Ref: **R/190/13**

Re: Land to the rear of 20 & 22 Broadmark Lane, Rustington.

We OBJECT to the proposed application for a large detached dwelling at the above site.

DRAWING TITLE
PROPOSED ELEVATIONS AND
STREET ELEVATION

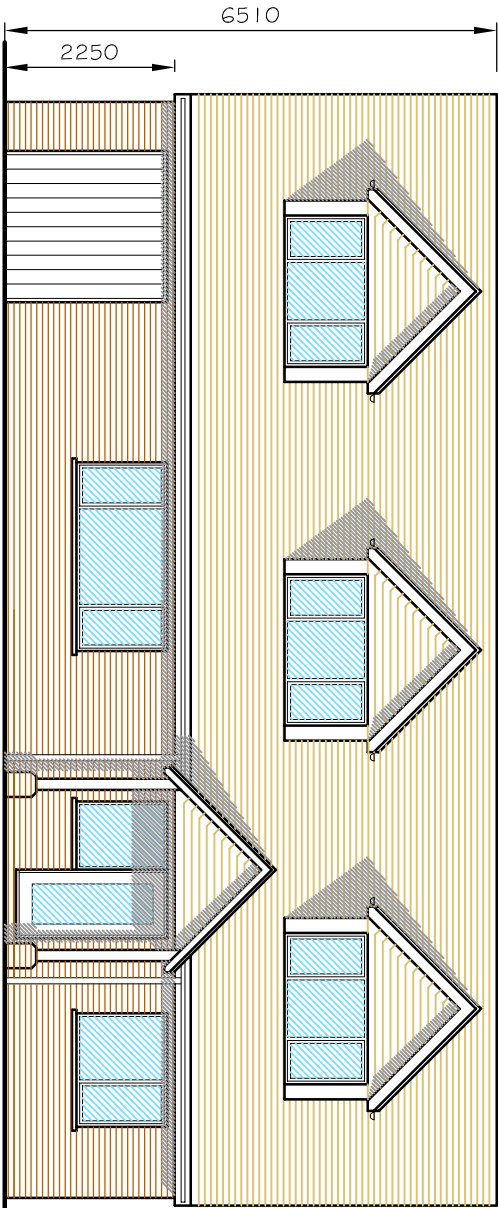
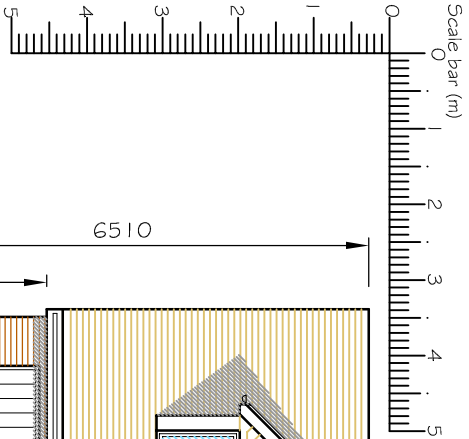
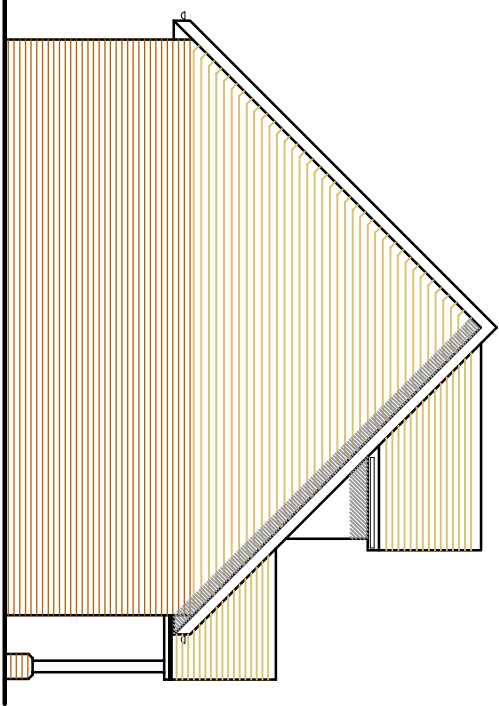
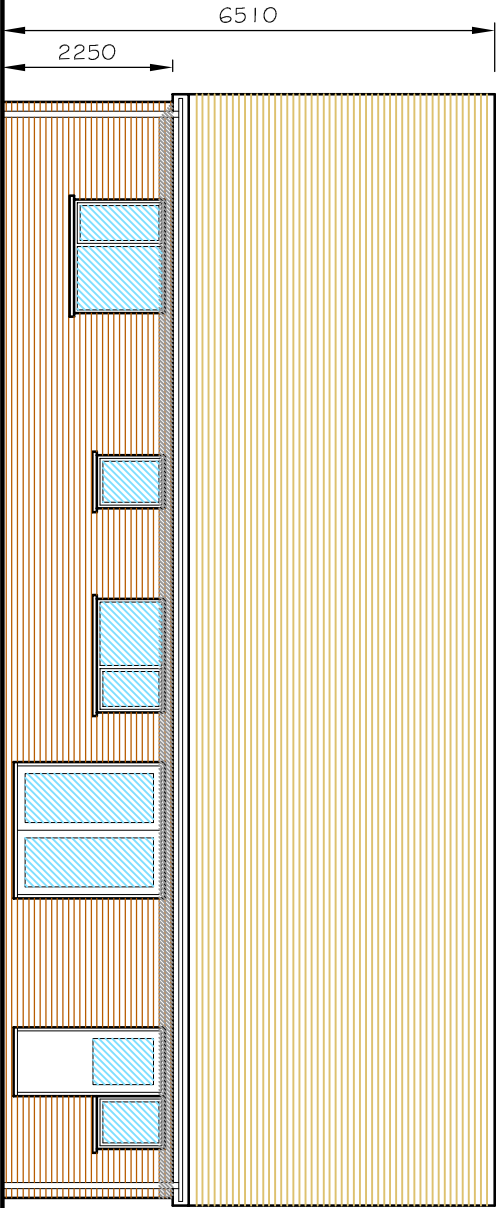
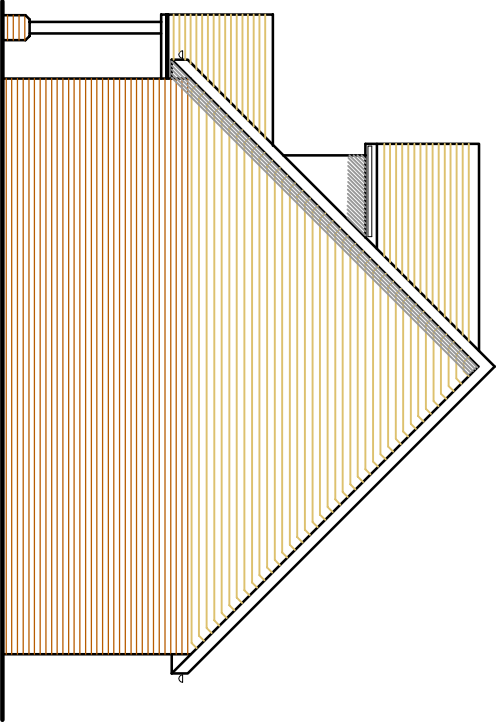
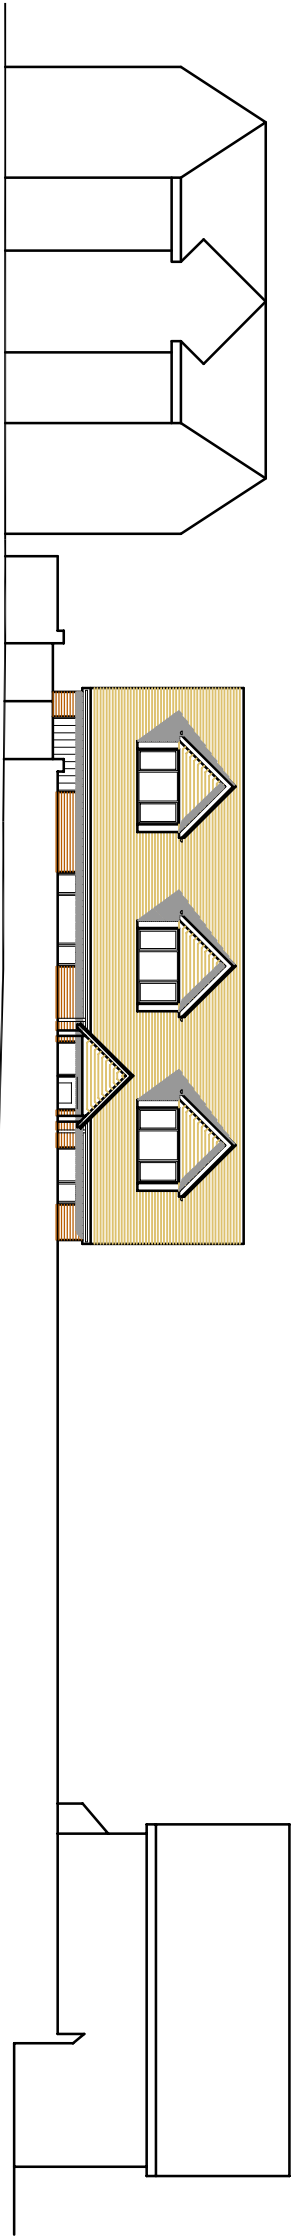
- 8) *The proposal due to its overbearing size (height and mass) will result in significant shadowing and loss of light to the gardens of 18,20 and 22 Broadmark Lane.*

DRAWING TITLE
PROPOSED FLOOR PLANS & ROOF PLAN

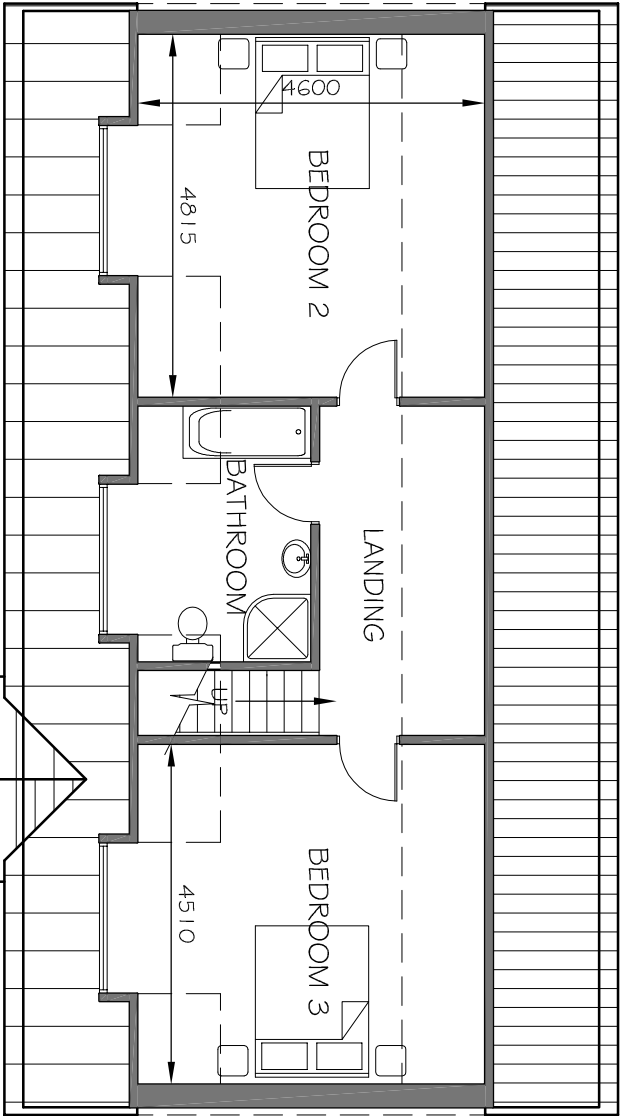
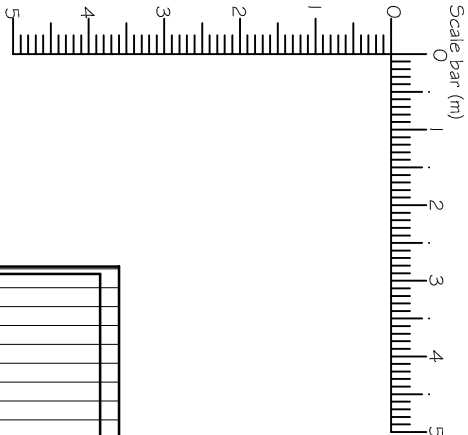
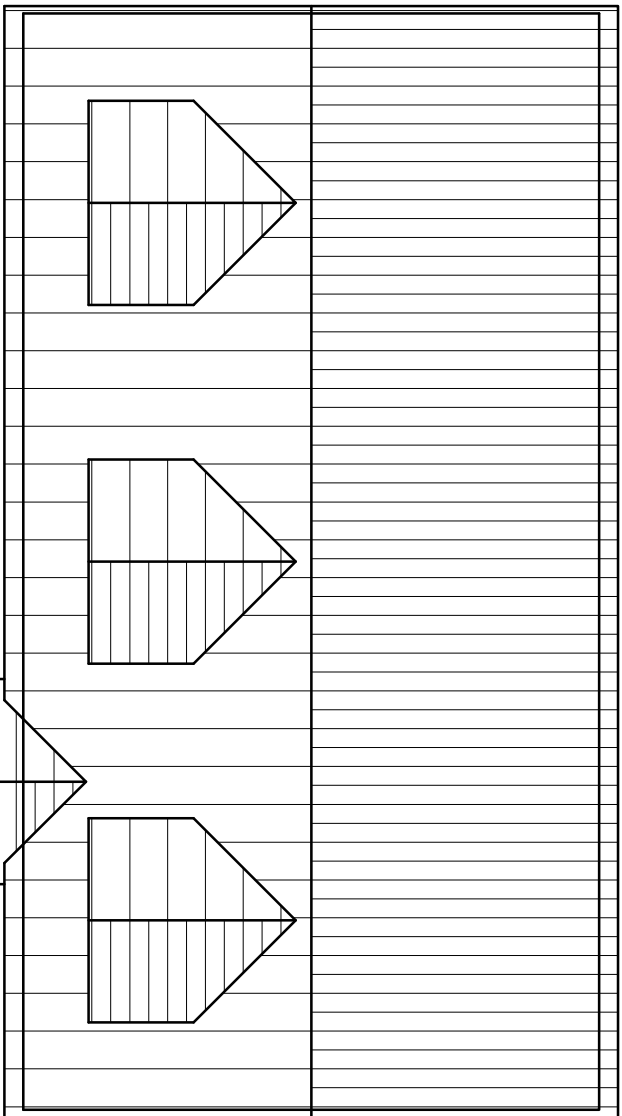
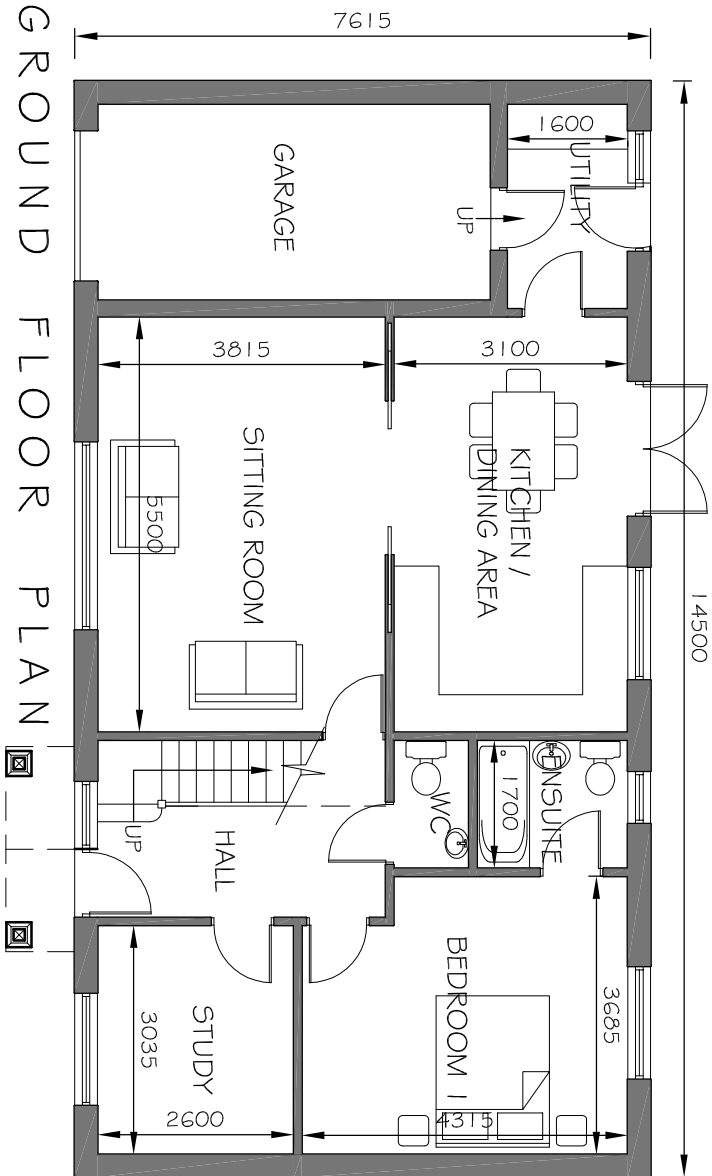
- 1) The house proposed then had a footprint of approximately 70 sq.ms. The house now proposed has a footprint of approximately 112 sq.ms. This is a 60% increase in the size of the building.

DRAWING TITLE
SITE LOCATION AND LAYOUT PLANS

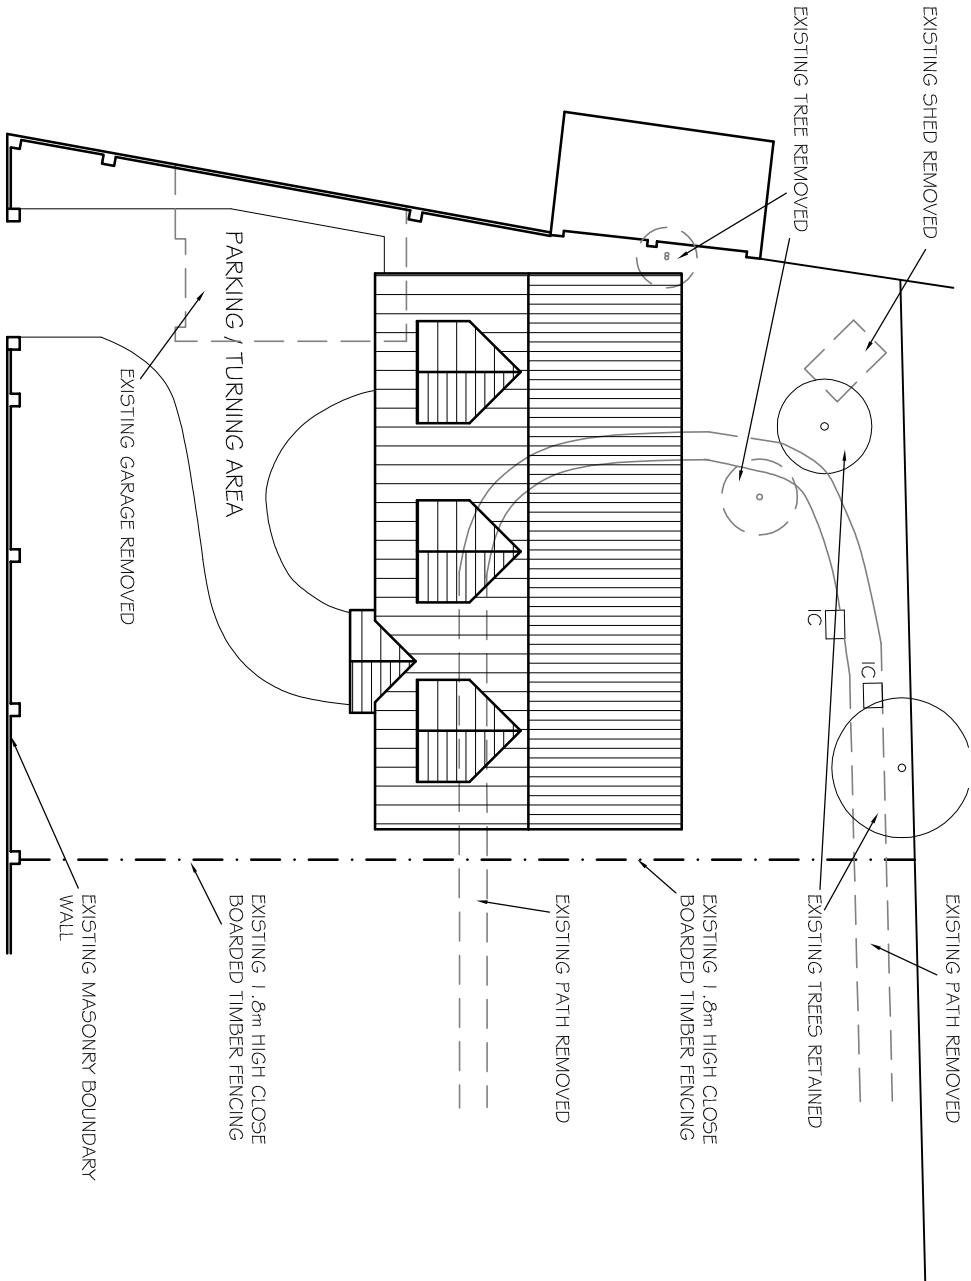
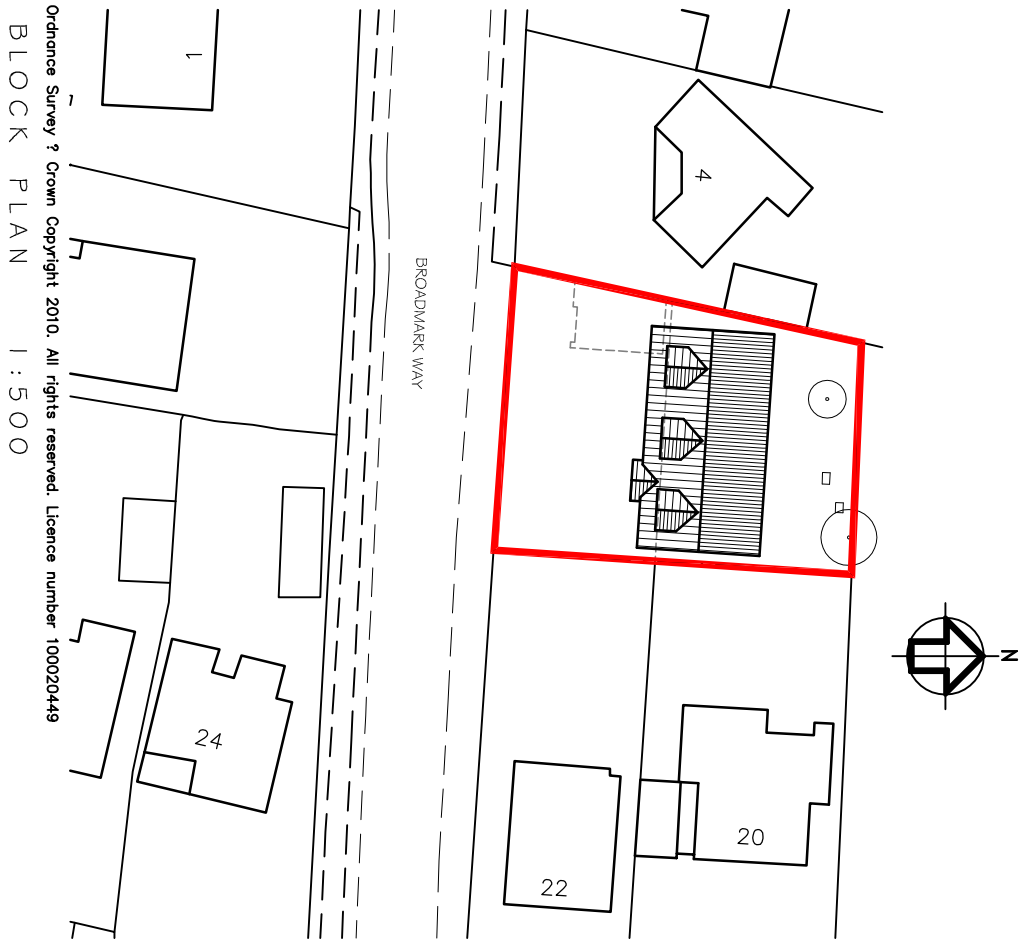
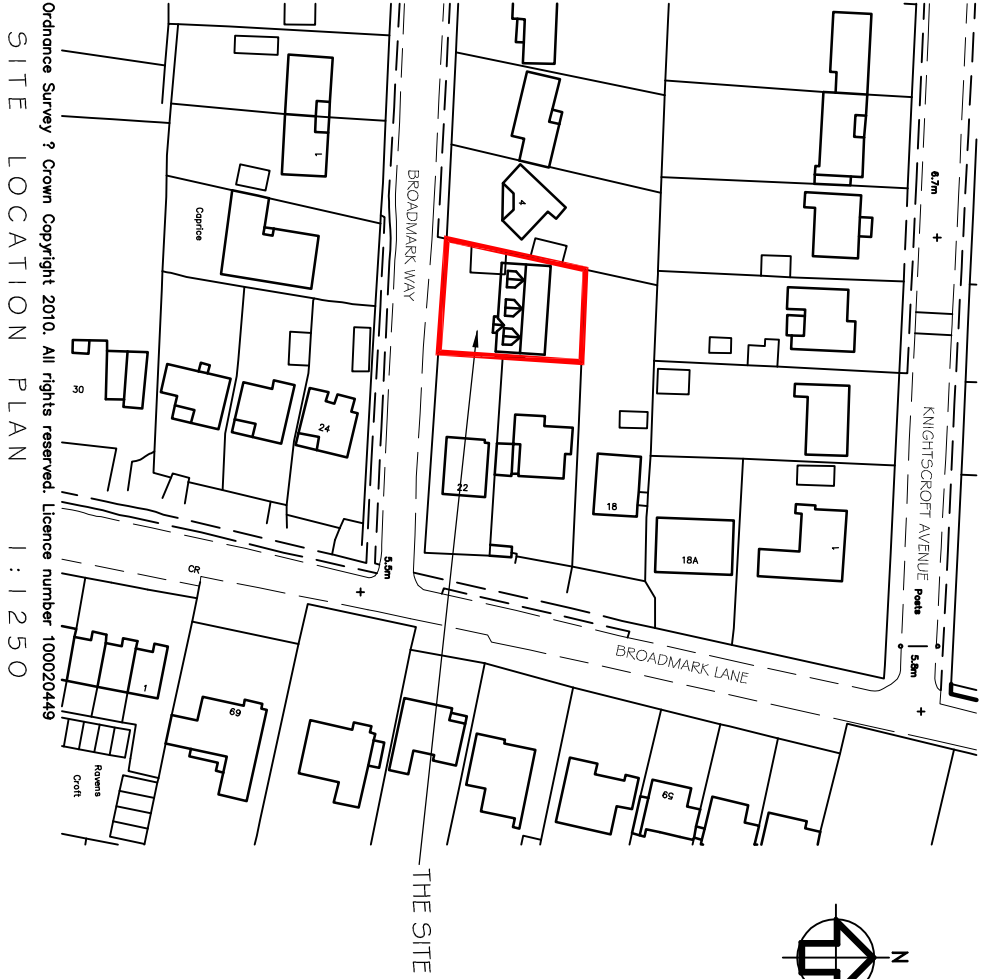
- 2) The 2010 proposal was sited between the rear of 22 Broadmark Lane, some 13 metres from its rear wall, and 4 Broadmark Way, some 7.5 metres from its flank wall. The house now proposed is 9.5 metres from the rear wall of 20 Broadmark Lane, and 4 metres away from the flank of 4 Broadmark Way. This is 27% closer to Broadmark Lane, and 46% closer to 4 Broadmark Way.

- 3) The 2010 proposal reduced the garden size of 22 Broadmark Lane by approximately 170 sq. metres, making both its overall plot size and that of the proposed dwelling uncharacteristically small. The house now proposed reduces the garden size of both 20 and 22 Broadmark Lane by approximately 400 sq. metres making both existing plot sizes uncharacteristically small.

- 4) The depth of the proposed plot now is 23 metres, compared to the depth of the other adjacent plots along Broadmark Way of 34 metres. The plot is 32% shorter than that prevailing along Broadmark Way.

- 5) The depth of the proposed rear garden is 5.6 metres, whilst that prevailing along Broadmark Way is approximately 15 metres. This proposal is only 37% the depth of the prevailing rear garden amenity space along Broadmark Way. With regard to 20 Broadmark Lane the proposal reduces the rear garden depth from 24 metres to 9 metres – a 62% decrease. For 22 Broadmark Lane the proposal reduces the rear garden from 30 metres to 13 metres – a 56% decrease.

Furthermore, as is readily seen on the Site Location Plan and the Block Plan, and is further emphasised by point 2 above, this new proposal is far more cramped on the site in relation to the existing properties at 4 Broadmark Way and 20 and 22 Broadmark Lane than was the 2010 scheme which was refused primarily on these grounds.
